**SECTION 4.55(1A) MODIFICATION APPLICATION – SSD 7388  
31 WHEAT ROAD, SYDNEY (THE RIBBON) – MOD 16**

This Modification Application (MOD 16) has been prepared by Ethos Urban on behalf of Tianlong Ribbon Pty Ltd (Greaton), pursuant to section 4.55(1A) of the *Environmental Planning and Assessment Act 1979* (EP&A Act) to modify Development Consent SSD 7388 relating to 31 Wheat Road, Sydney (the site). The development is better known as The Ribbon.

**L00 GA PLAN**

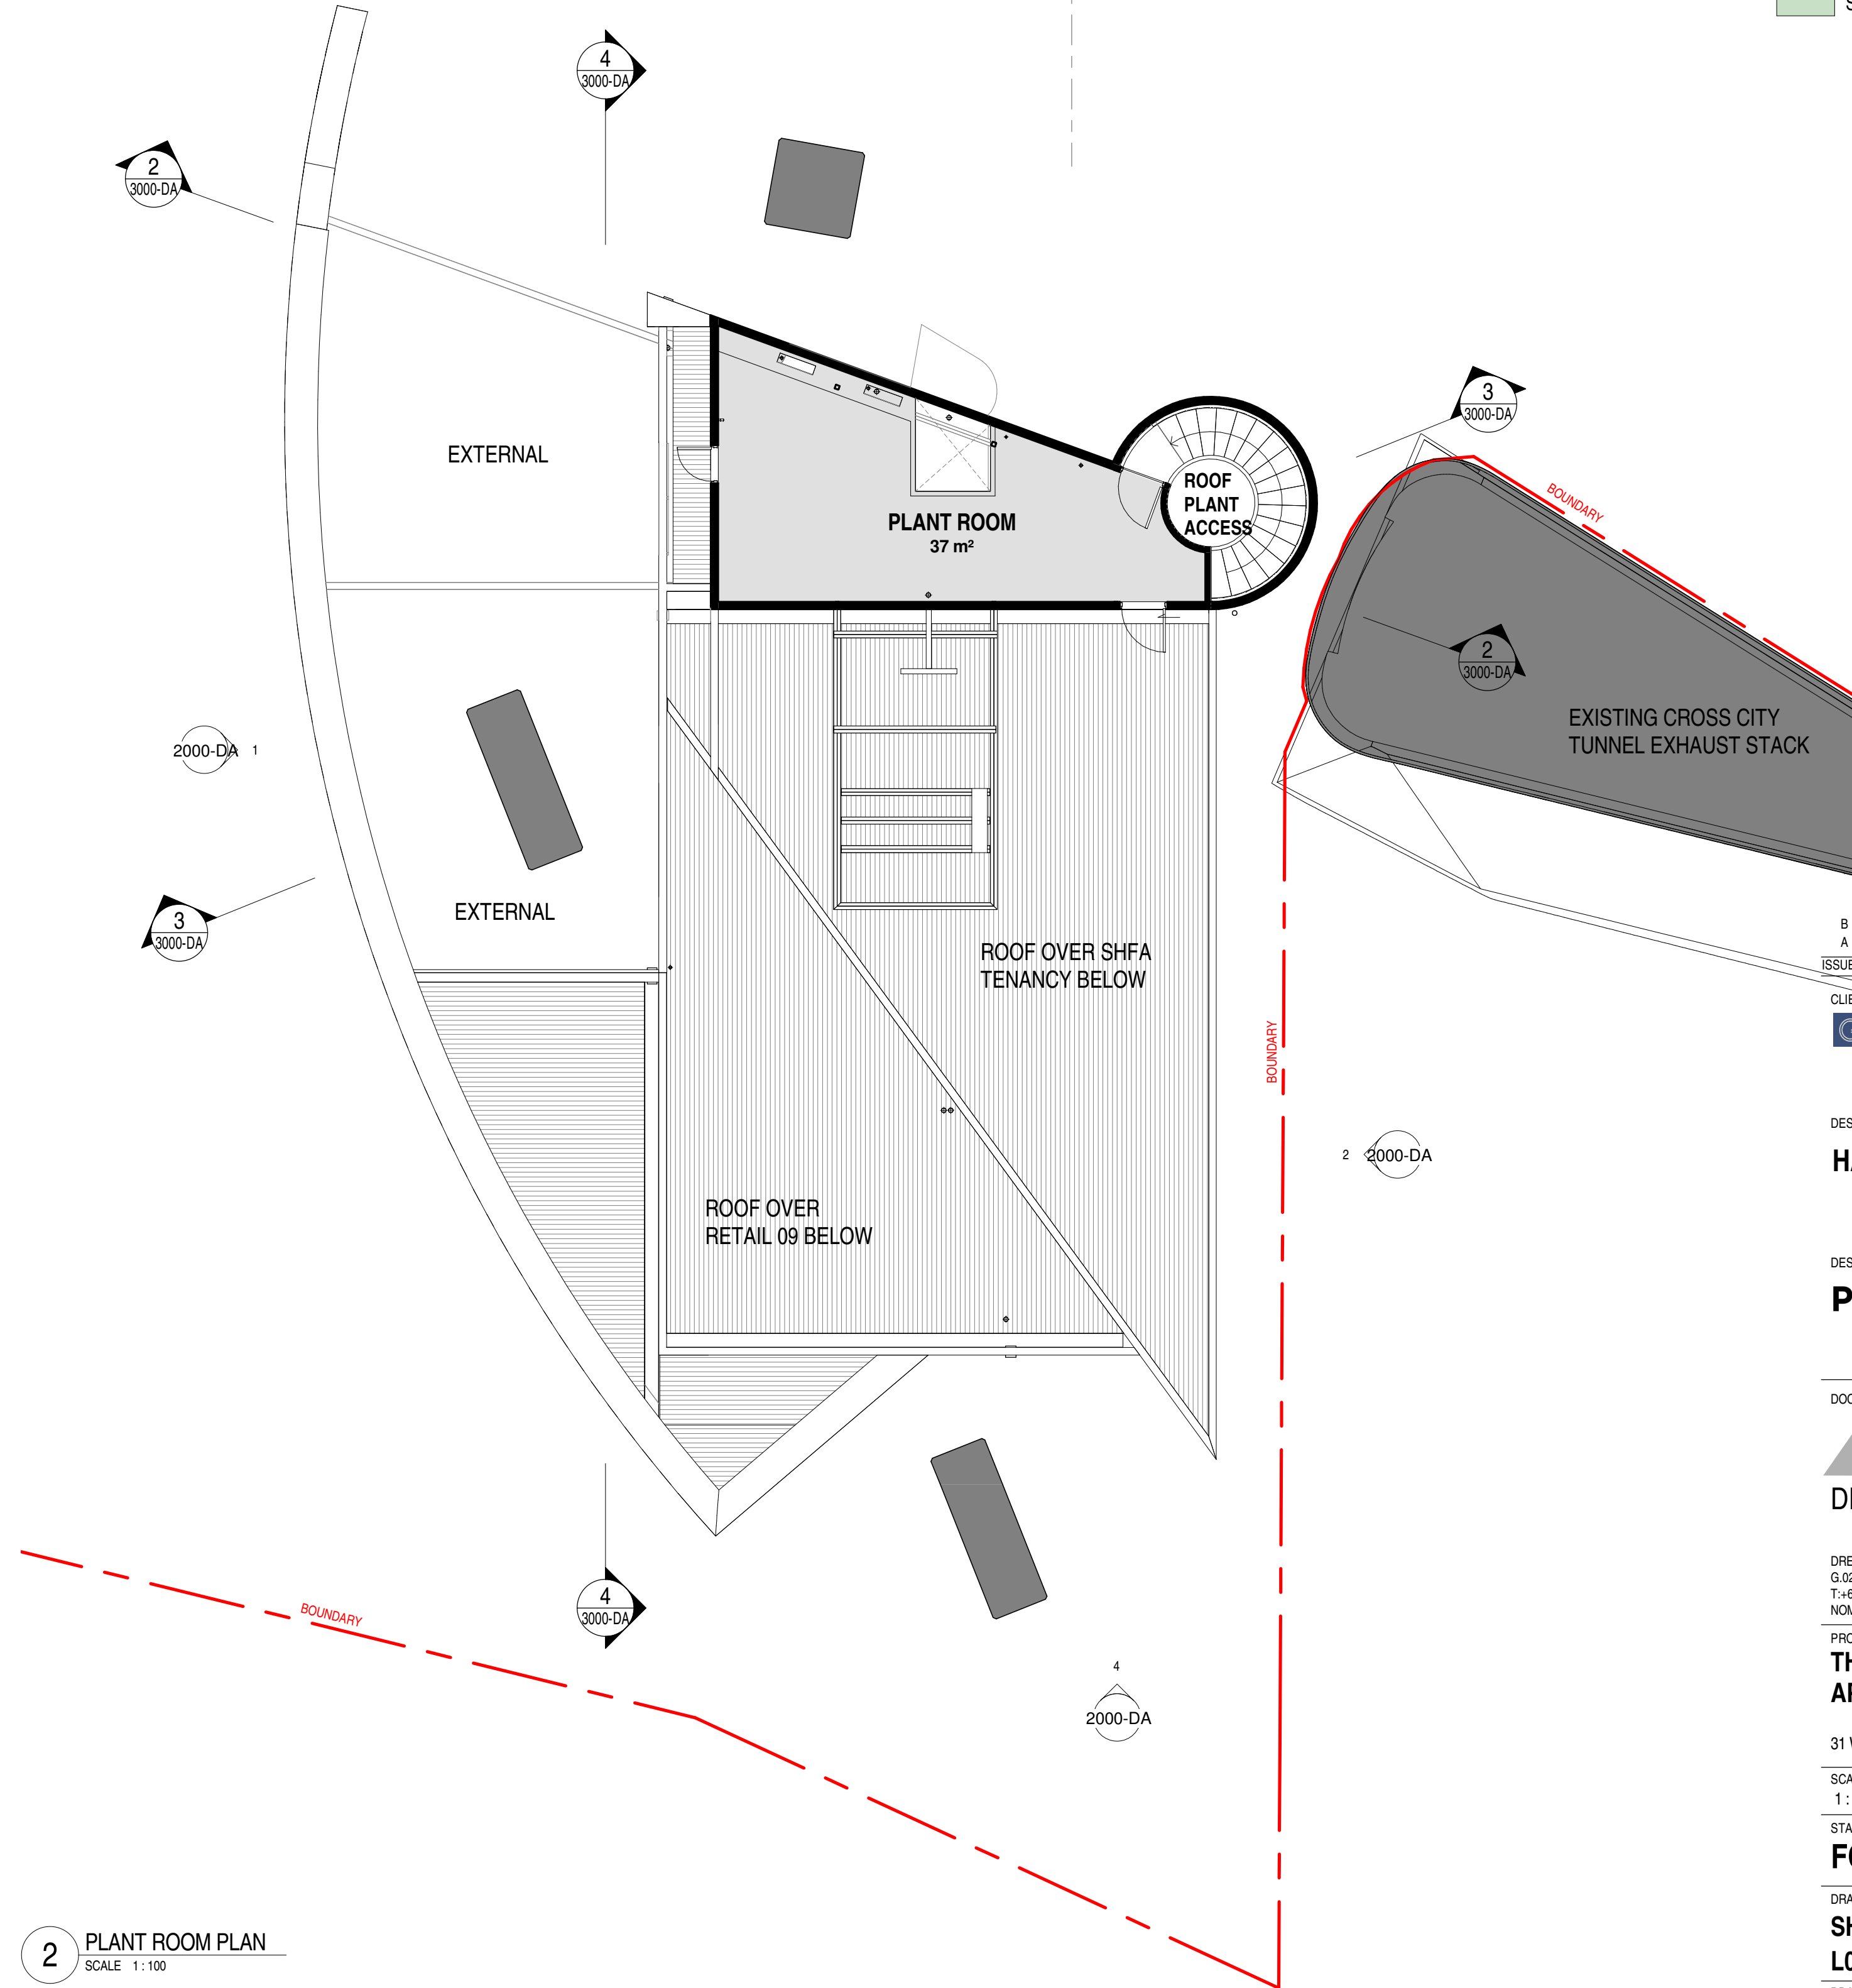
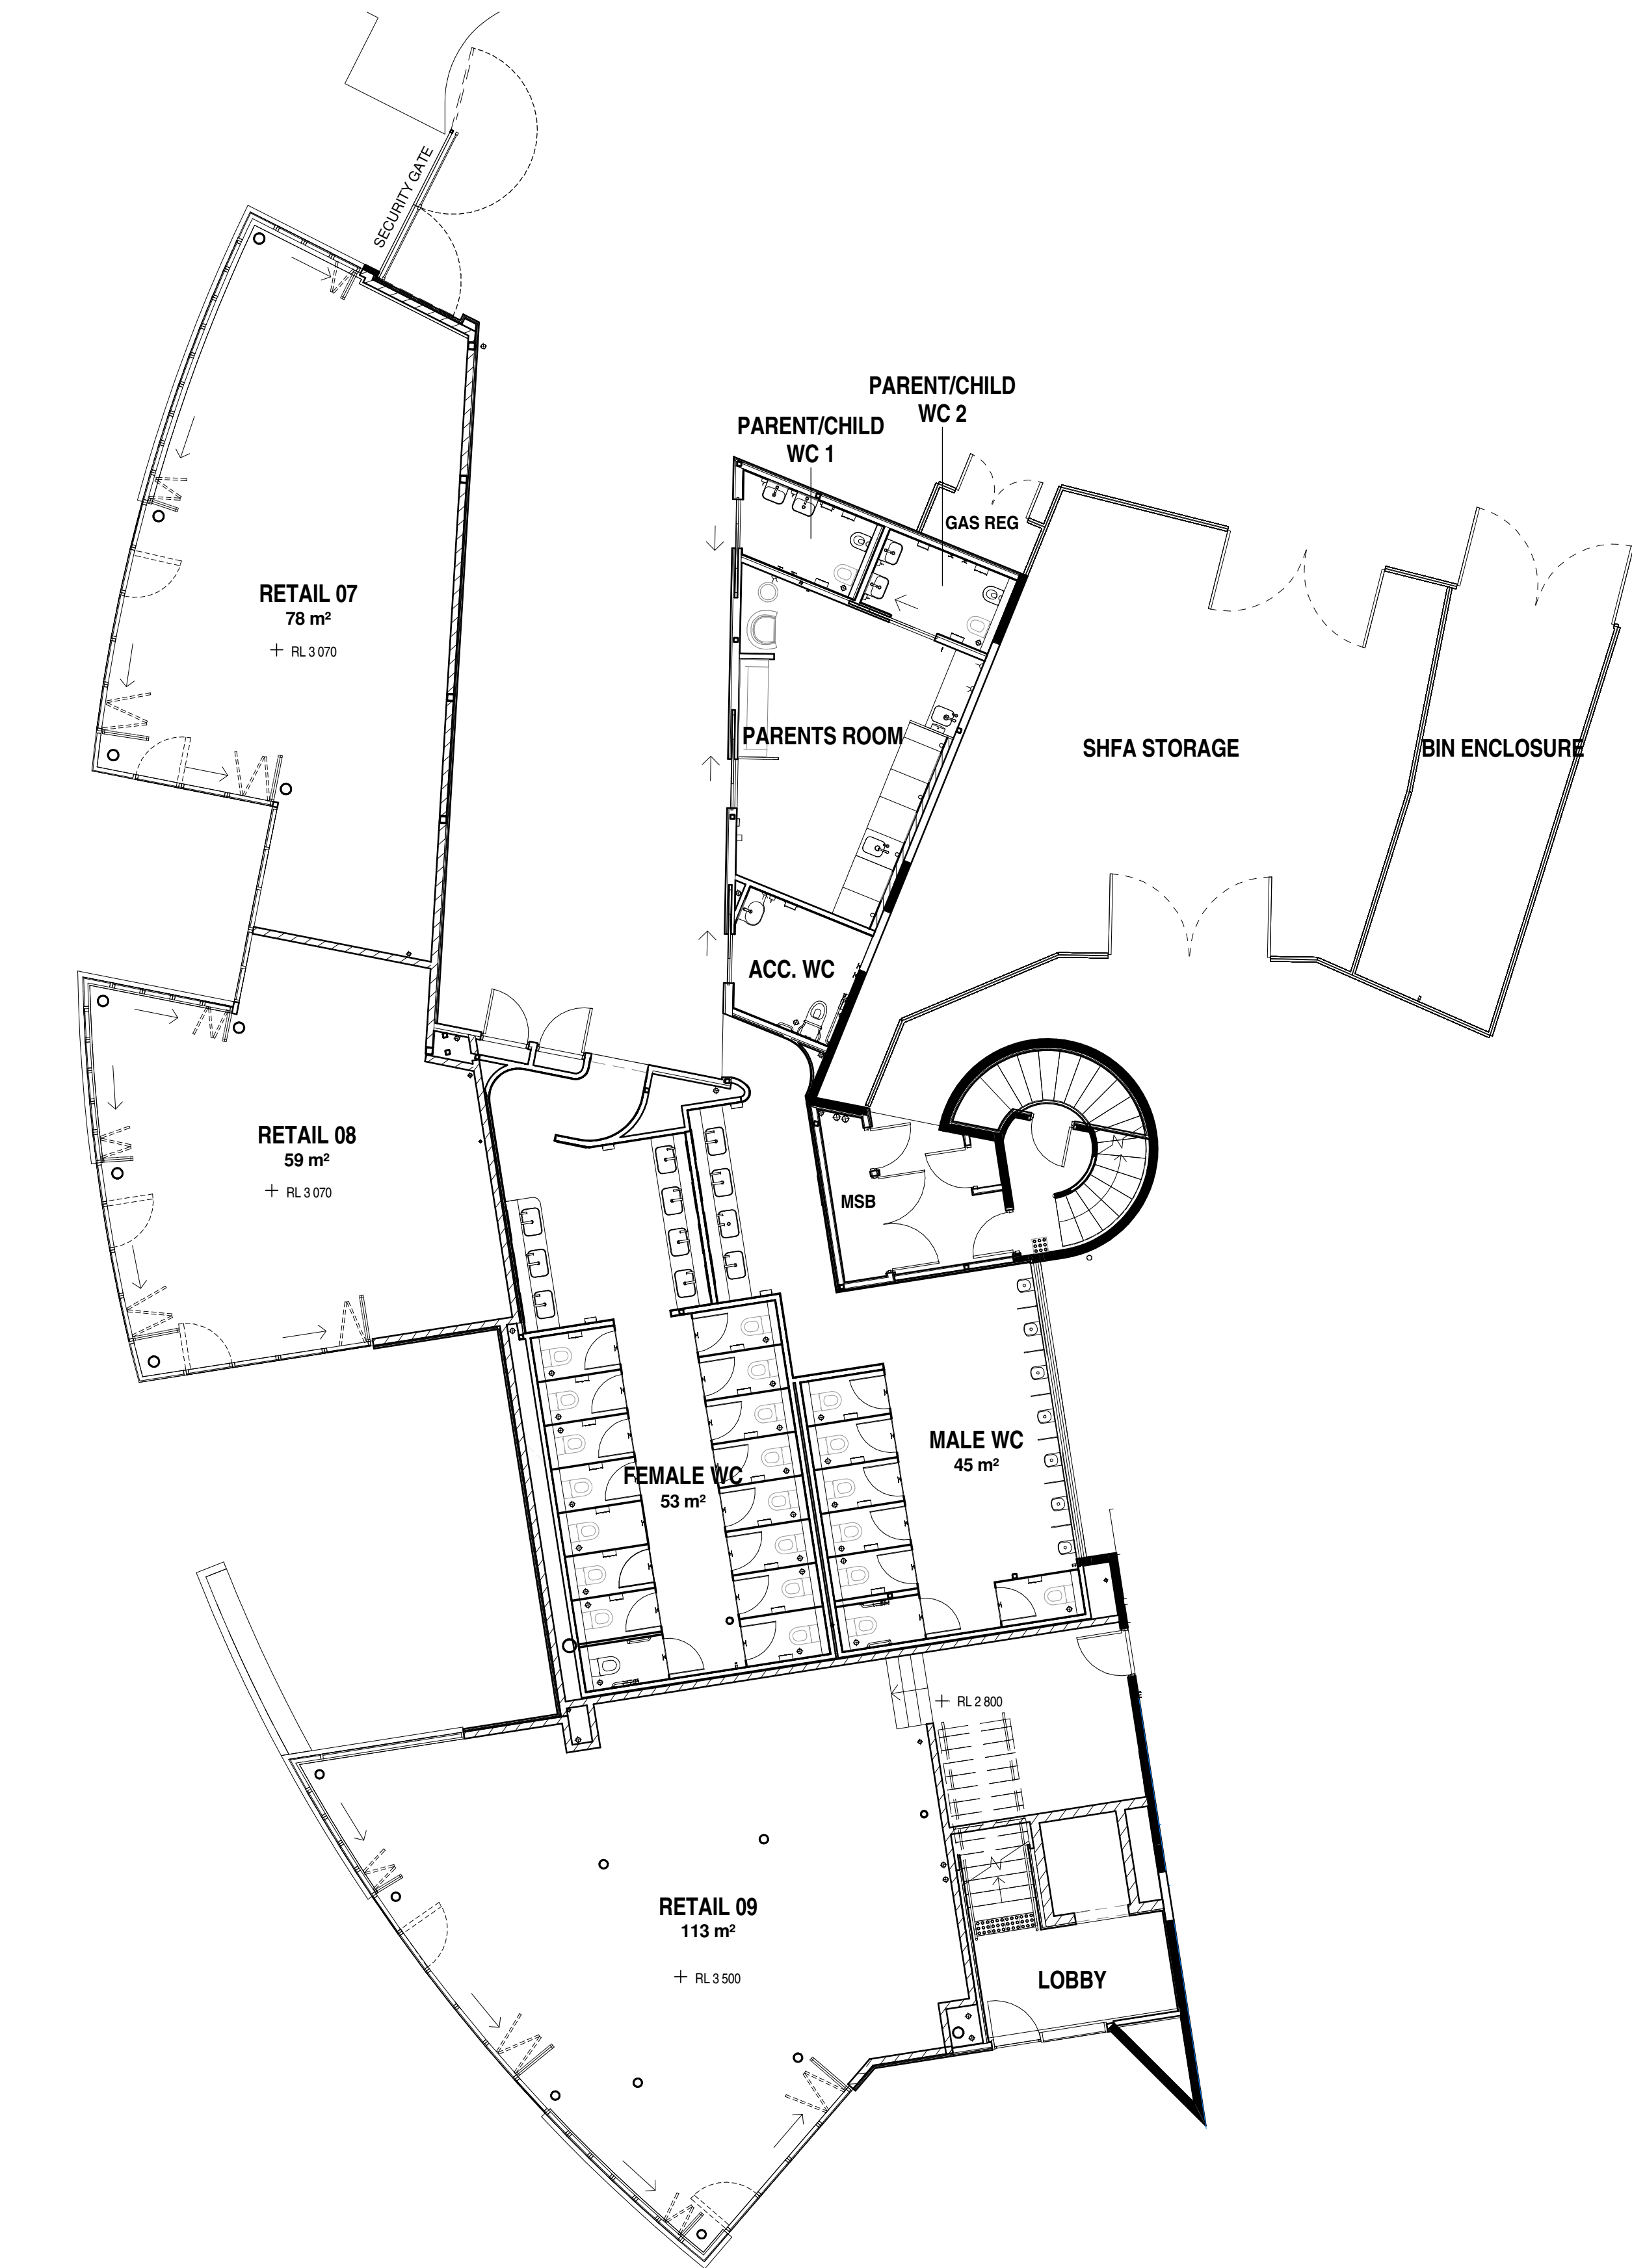
- Removal of Retail Tenancy 08 from the SHFA building to enable access to the Sydney Trains cable joint. Tenancy 08 will be replaced with additional public domain area.
- Ancillary architectural amendments incidental to the removal of Retail Tenancy 08.
- Reduction in extent of operable glazing for Retail Tenancies 07 and 09 and replacement with fixed glazing to meet ESD requirements.
- Swapping location of the SHFA lobby elevator and stairs to maintain clearances from the Sydney Trains cable line.
- Addition of an additional window to Retail Tenancy 07 to satisfy Condition B3 of the SSD 7388 consent.

The removal Tenancy 08 requires minor incidental architectural amendments where it previously interfaced with Retail Tenancies 07, 09, the amenities area and the SHFA office. The proposed architectural amendments are shown within the Amended Architectural Plans. This includes the removal of the Glass Reinforced Concrete (GRC) Band above Retail Tenancy 09, and a reduction in size of the southern extent of Retail Tenancy 07 (**Figures 1 – 2**).

1 WEST ELEVATION  
SCALE 1:100

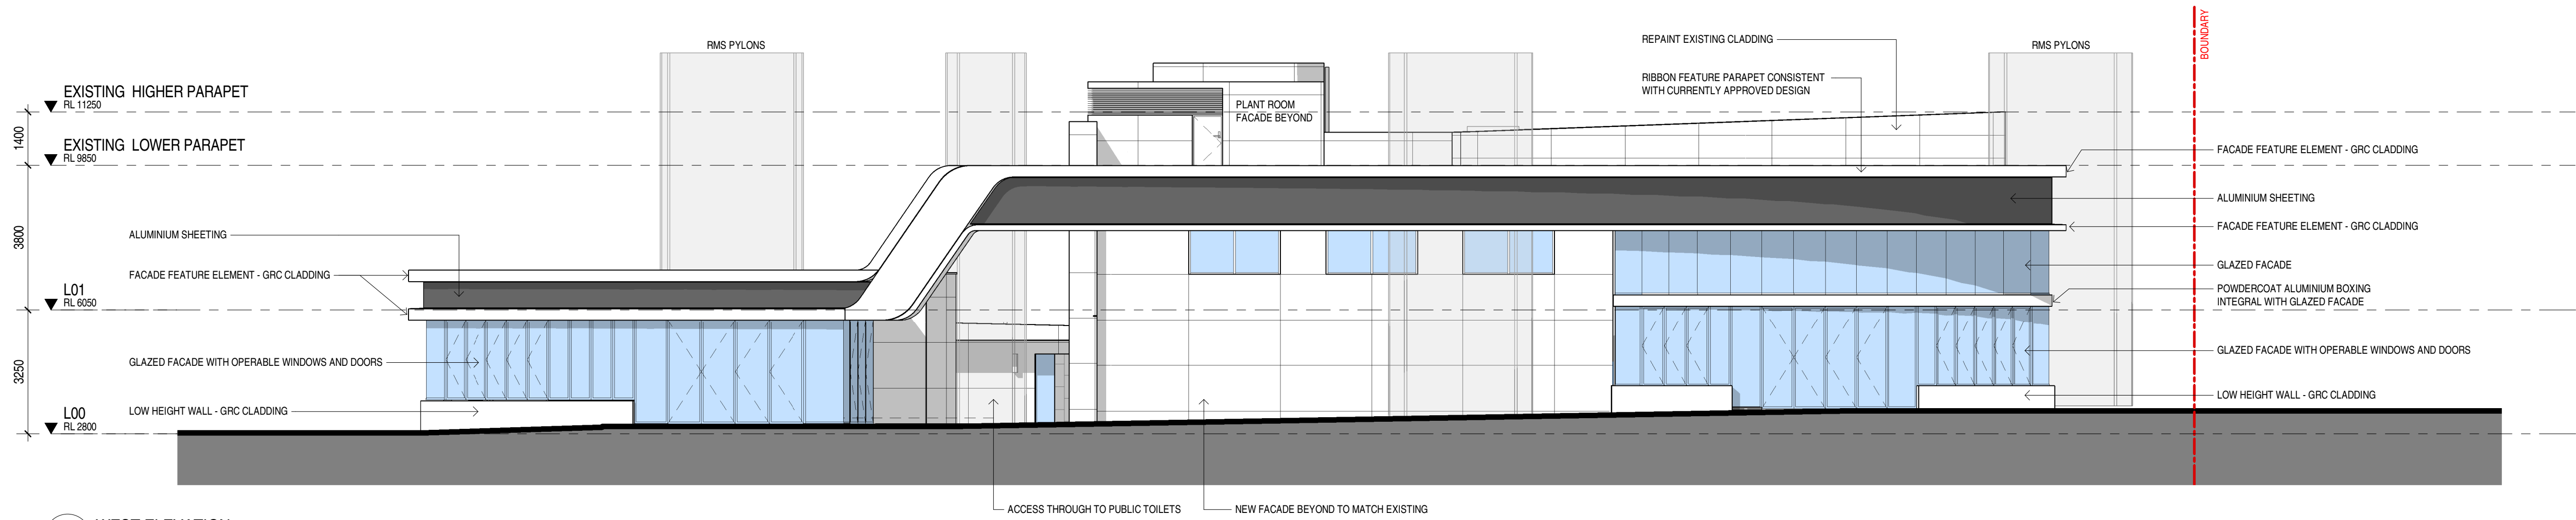
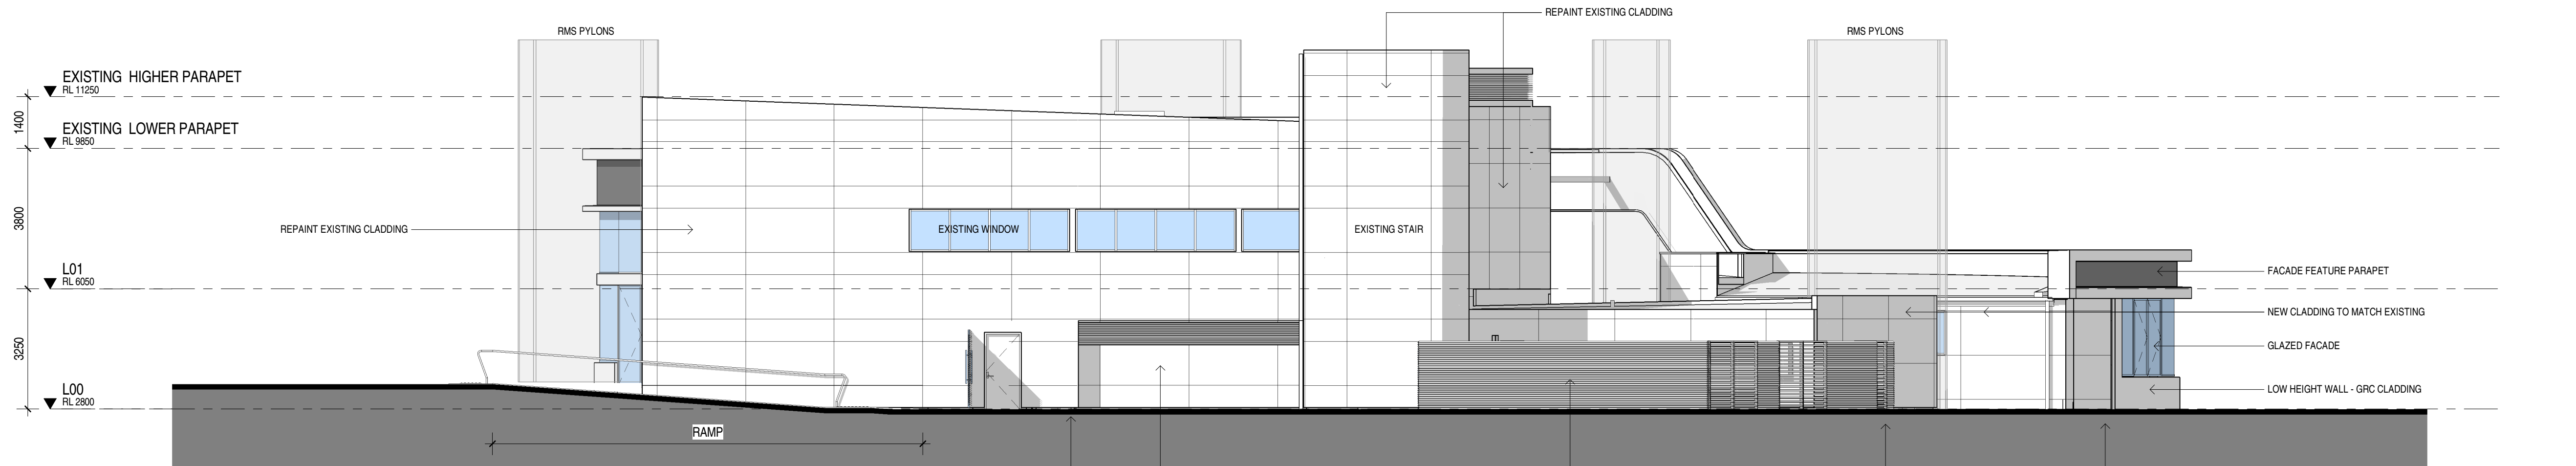
- Amendments are proposed to the glazing of Retail Tenancies 07 and 09. The extent of operable glazing is to be reduced and replaced with additional fixed glazing as shown on the Architectural Plans. This change is required to meet sustainability requirements and improves the SHFA building's energy performance, as discussed in **Section 6.3**.
- The SHFA lobby elevator and stairs are proposed to have their locations swapped to maintain clearances from the Sydney Trains cable line.
- An additional window has been added to the eastern façade of Retail Tenancy 07 (**Figure 3**). The additional window enables additional activation and casual surveillance to the public domain around the amenities area and is a design change required by Condition B3 of the SSD 7388 consent. Accordingly, Condition B3 of the SSD 7388 consent is proposed to be deleted as it is now to be satisfied.
